From: Simon Davis
Sent: 19 September 2018 16:39
To: 'JGuilfoyle'
Subject: RE: AL/74/18/PL Woodgate Farm

1 : 50

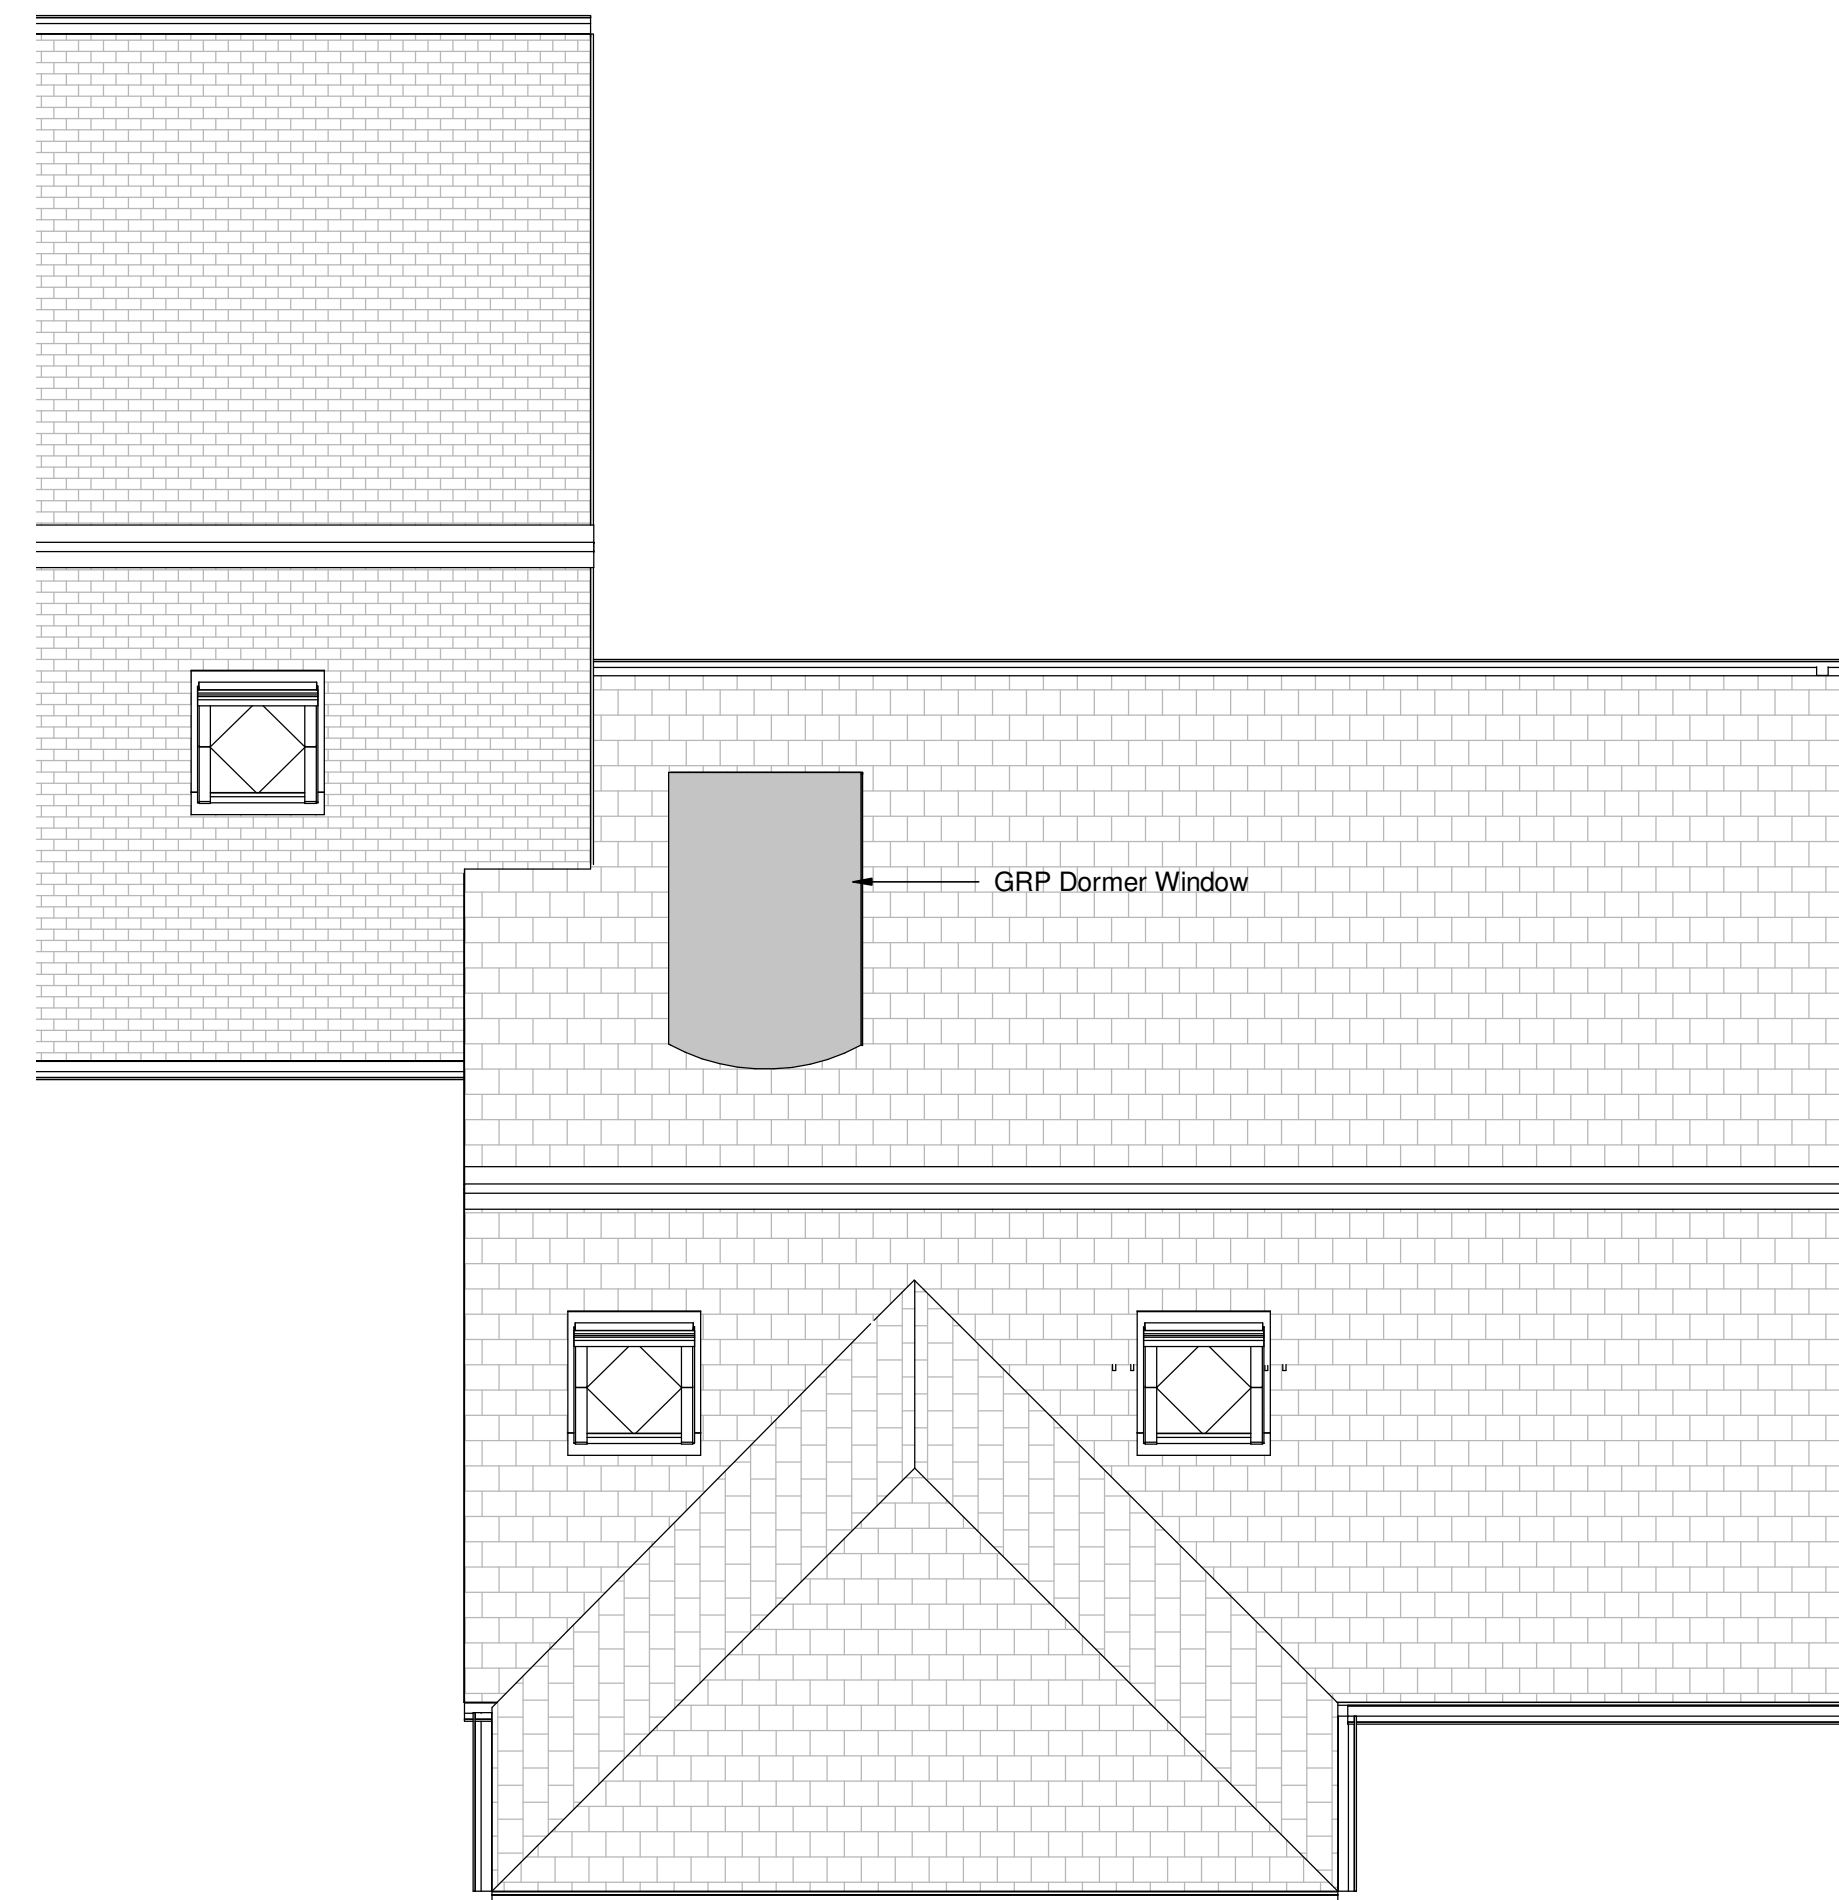
Their comment was that: "Contrary to policy H1 of the APC Neighbourhood Plan, the proposed dormer is not in keeping with surrounding properties."

Further to our conversation, I have had a look at the plans and discussed with my Team Leader. I consider that it would be difficult to argue harm associated with this small single dormer window and therefore, I will, after all, be able to support the proposal. This will need to go to Planning Committee with the next available on the 3rd October. Can you agree to an EoT until the 4th October please.
